# CITY OF ALBUQUERQUE

**Re: Los Altos Storage Unit**  
**9501 Lomas Blvd NE Albuquerque NM**  
**Transportation Development Final Inspection**  
Engineer's/Architect's Stamp dated 05-20-2018 (J20D039)  
Certification dated ??-??-??

TRAFFIC CIRCULATION LAYOUT PLAN

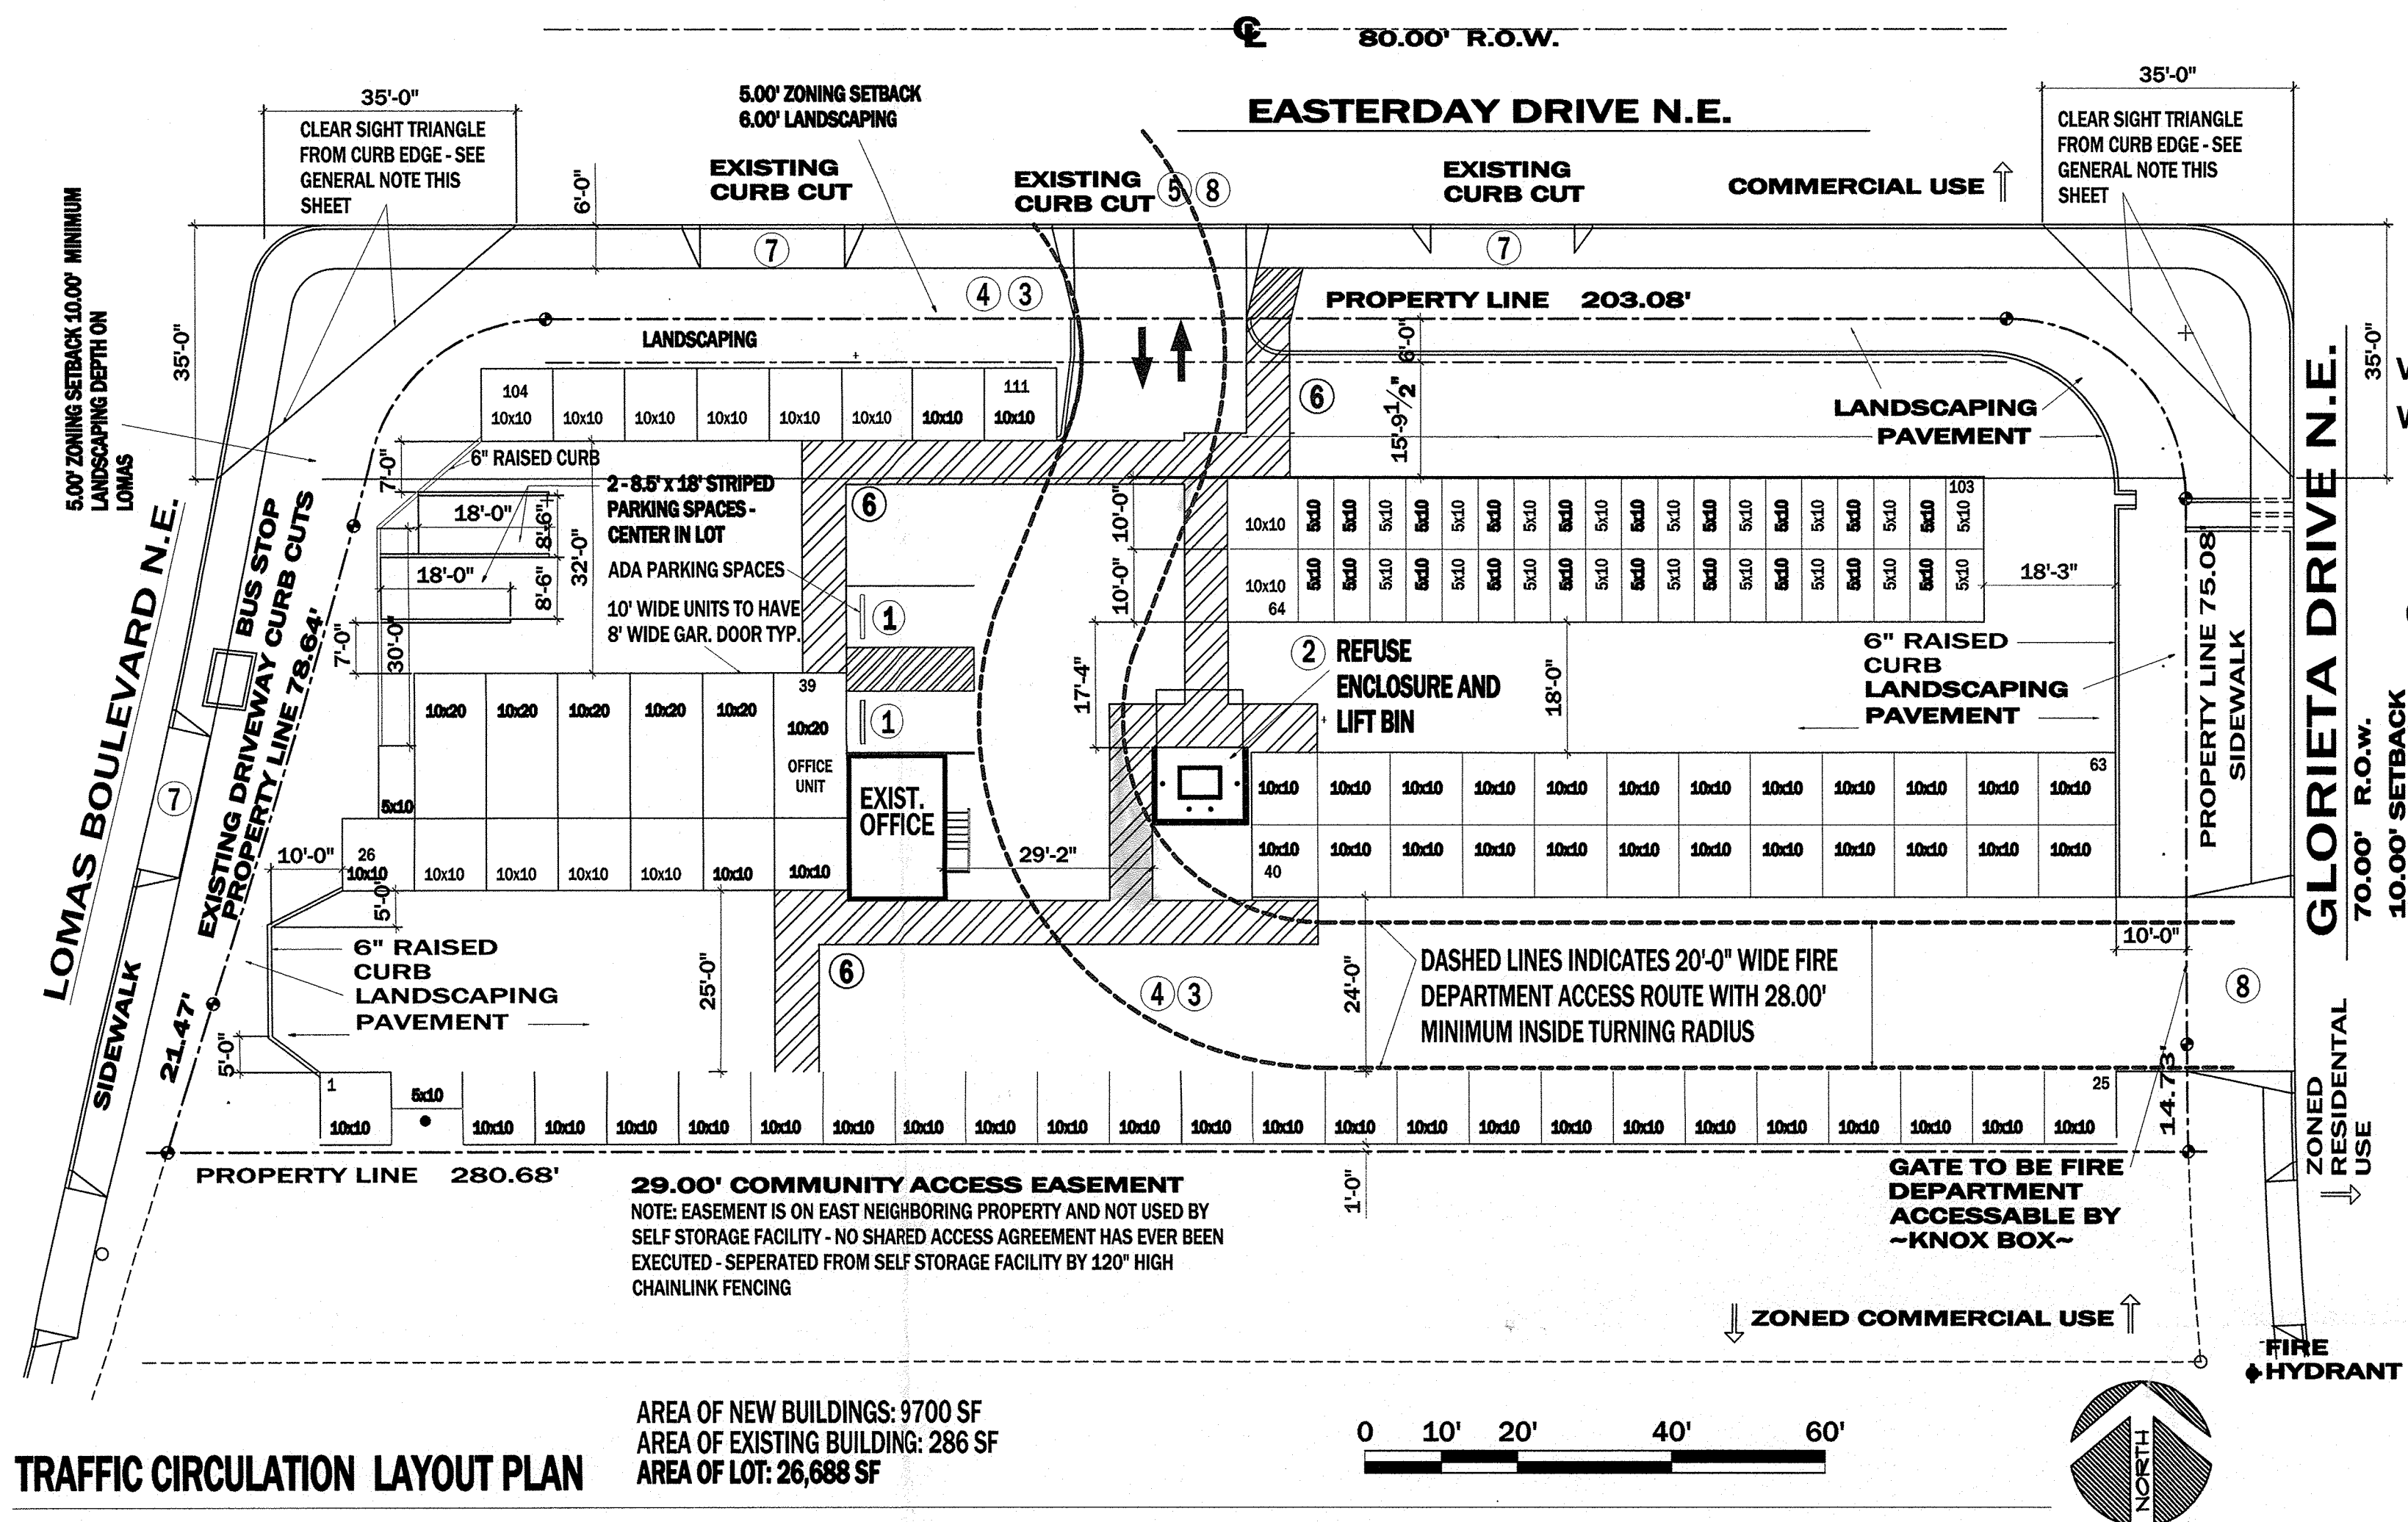
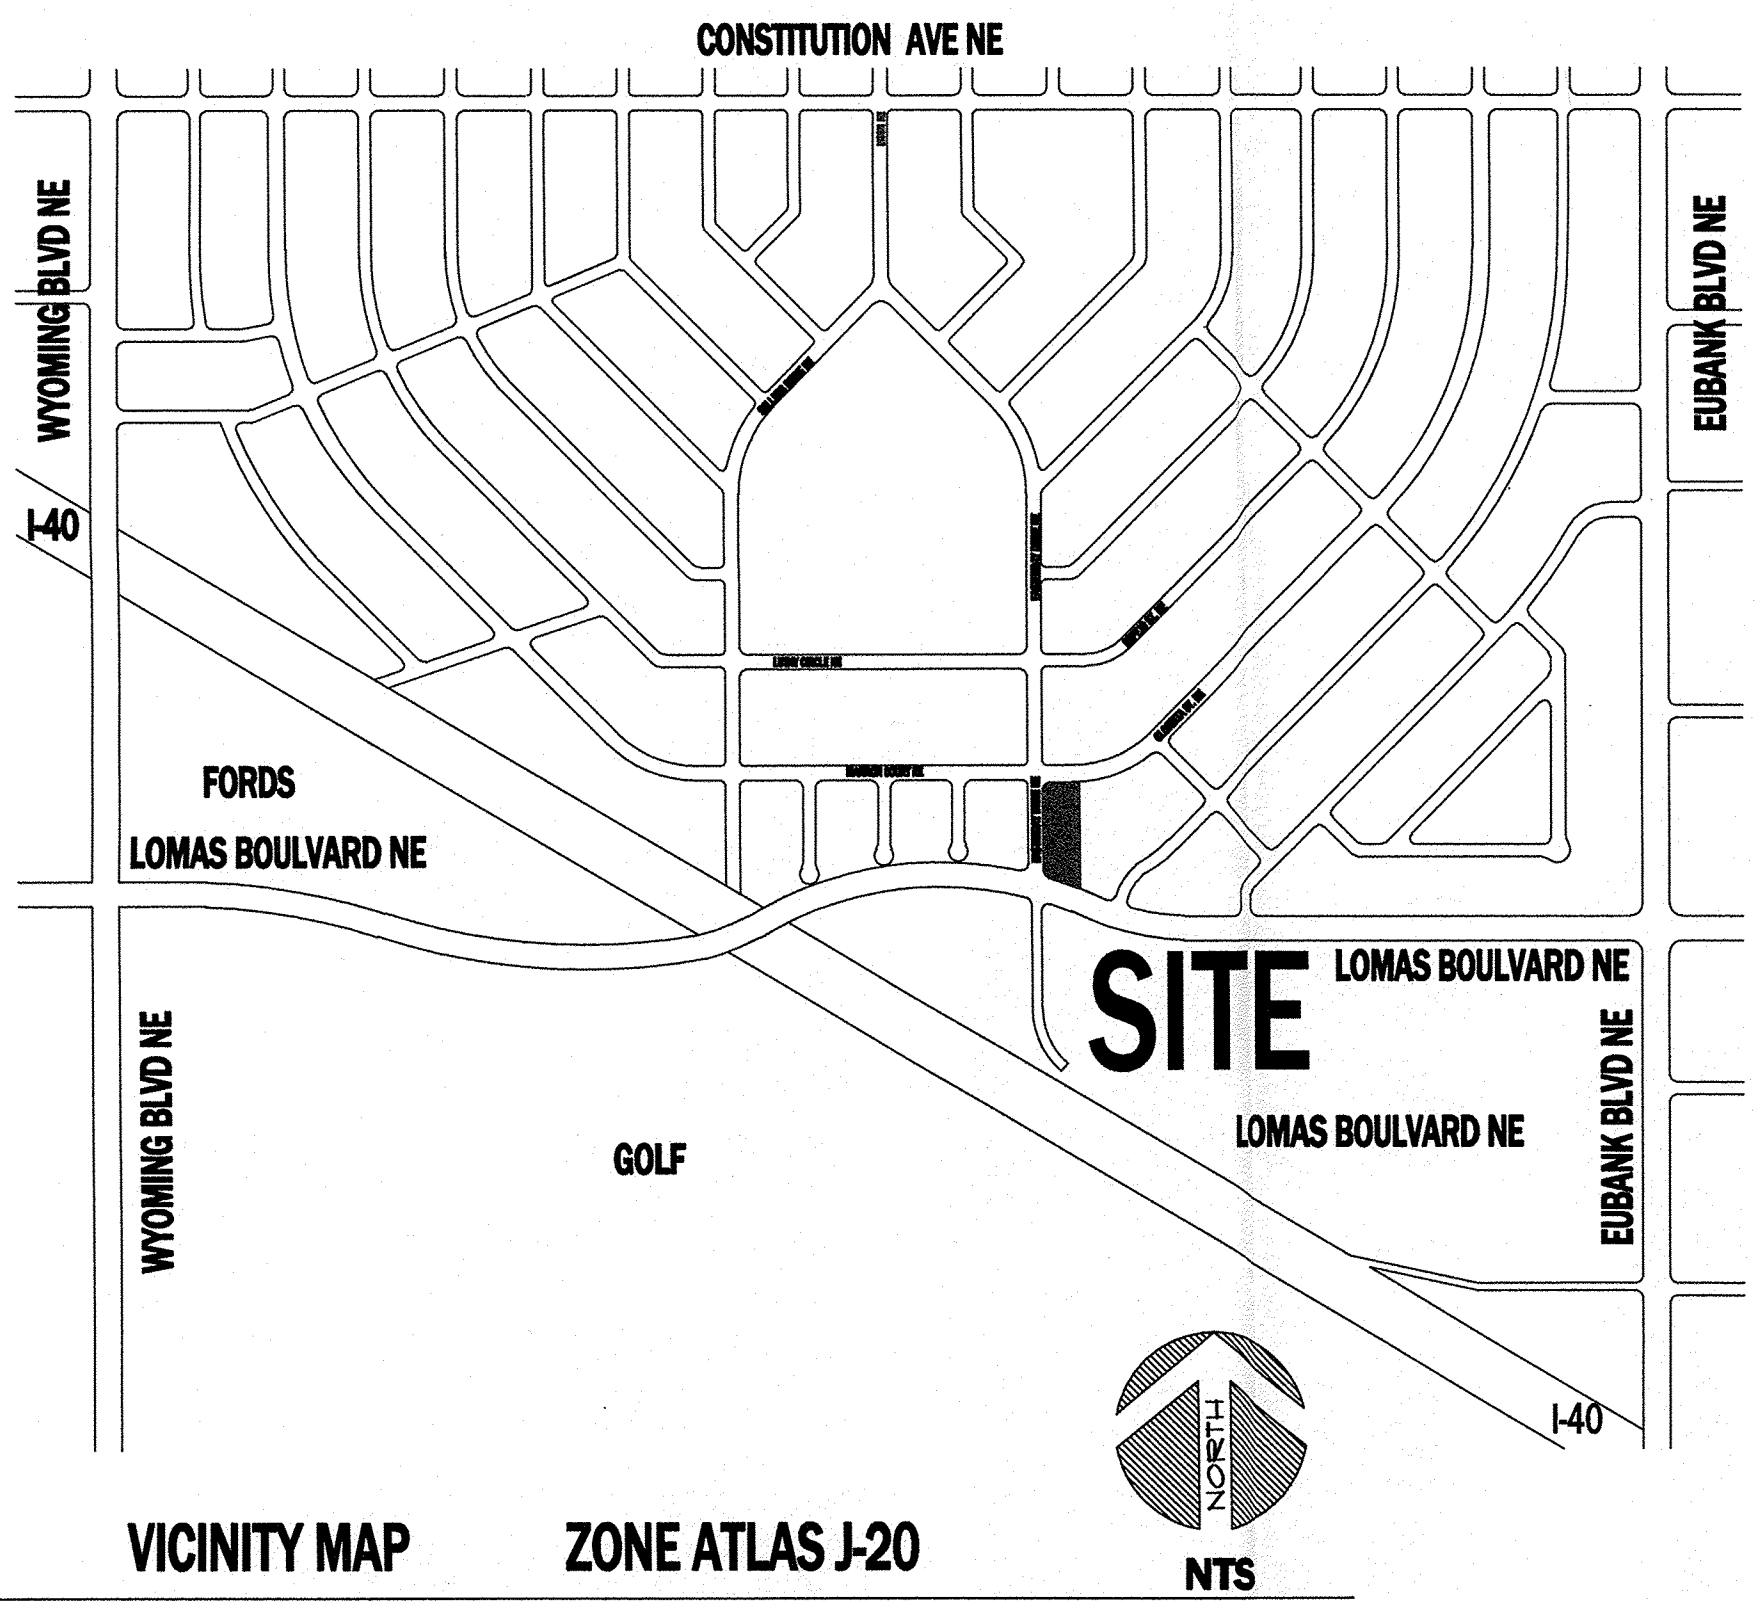
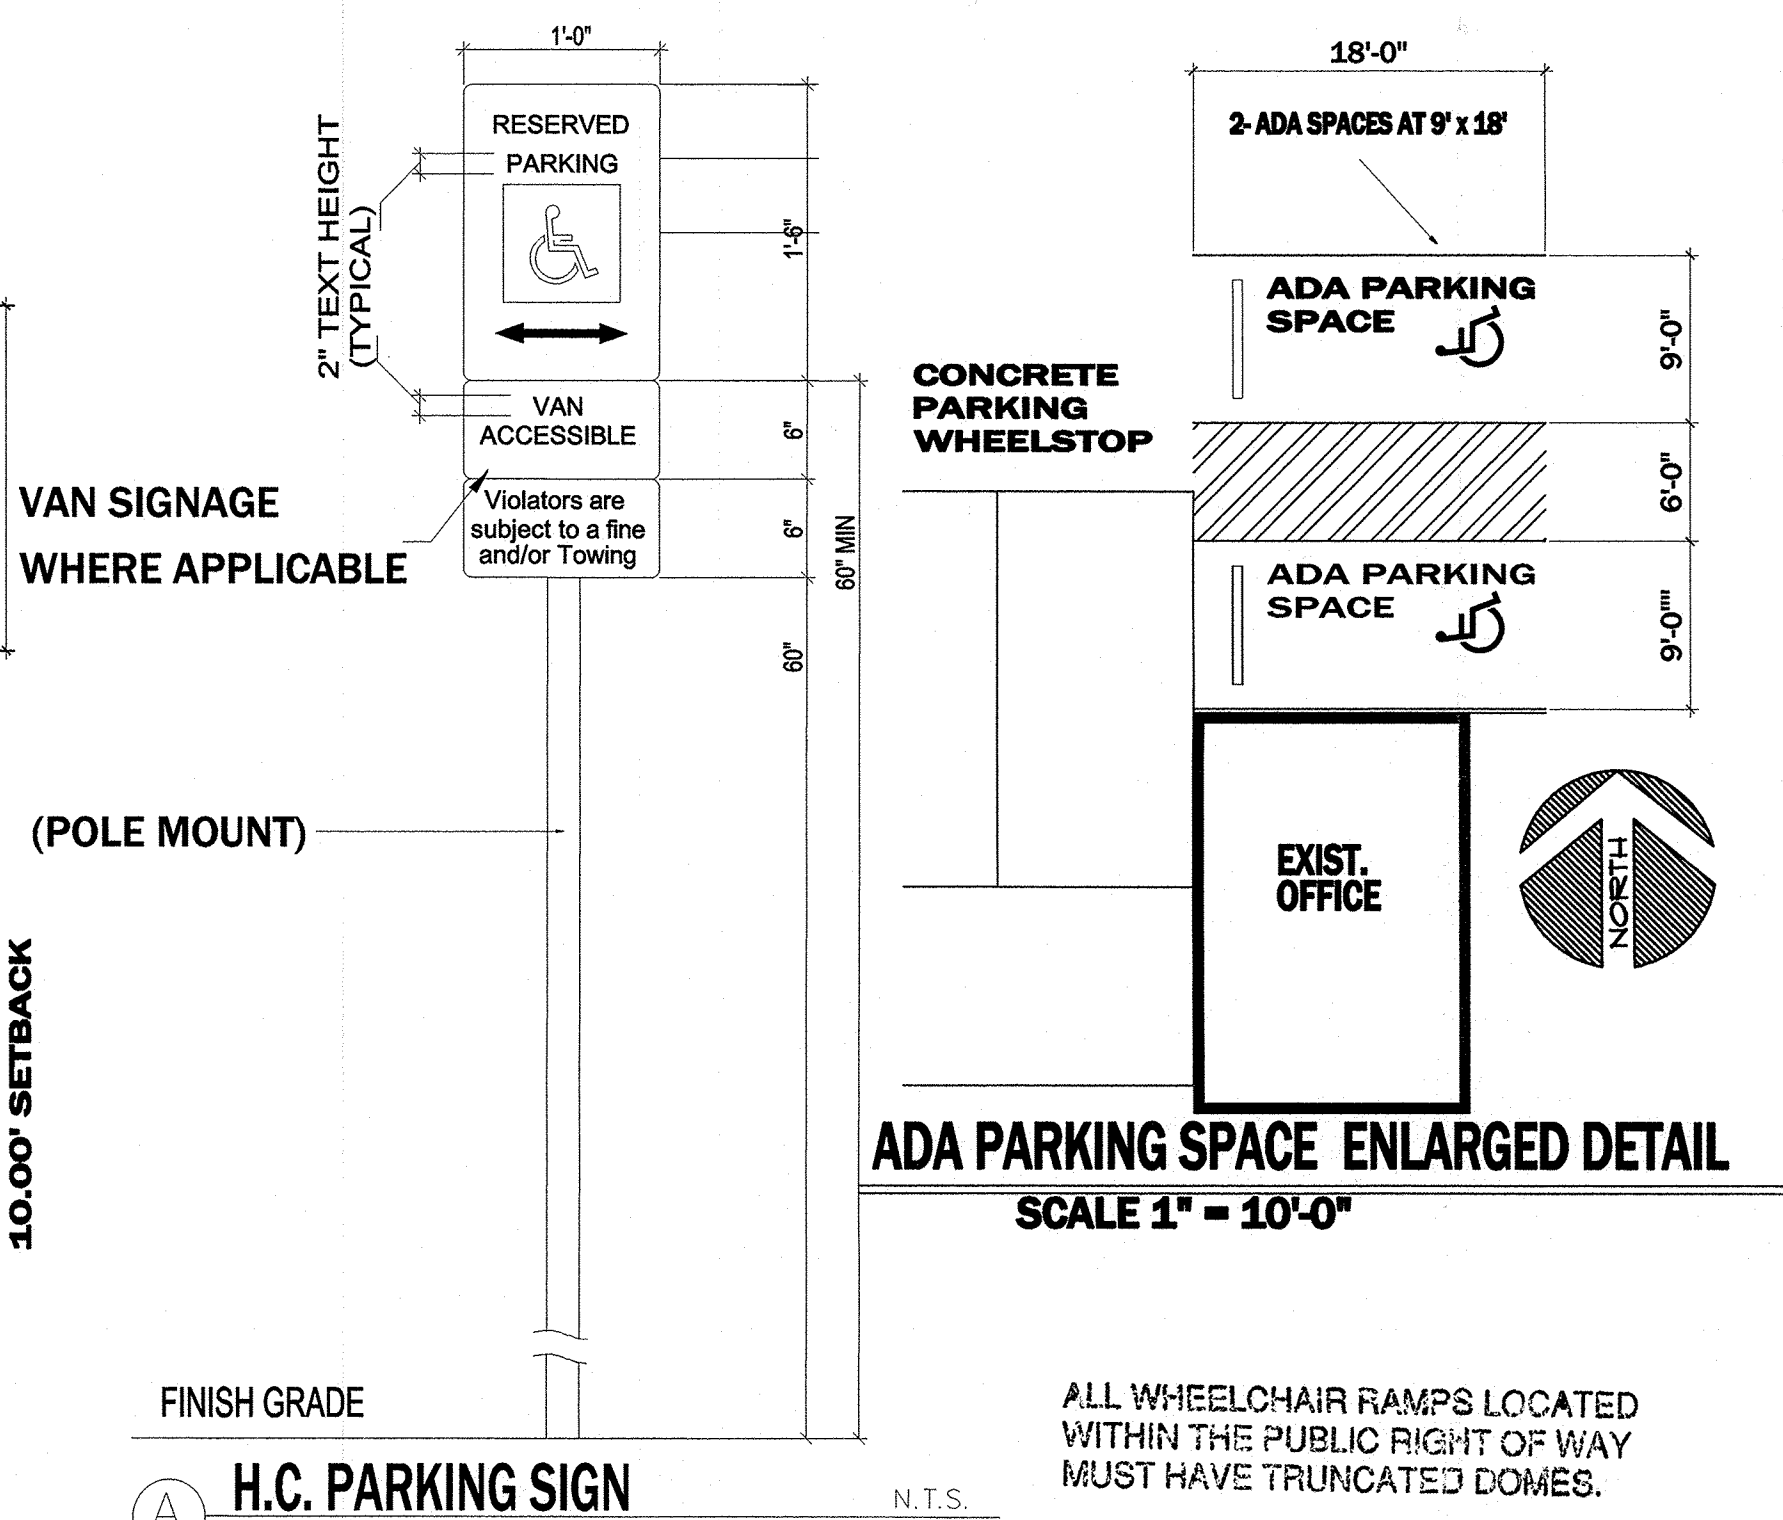
- The certification date is wrong please correct that.
- Number 6 on the keyed note does not seem to exist. Please provide an access path from public sidewalk.

- The ADA access needs to have a "NO PARKING"
- Please re-submit to the [PLNDRS@cabq.gov](mailto:PLNDRS@cabq.gov) whenever this site is ready for a CO to be published.
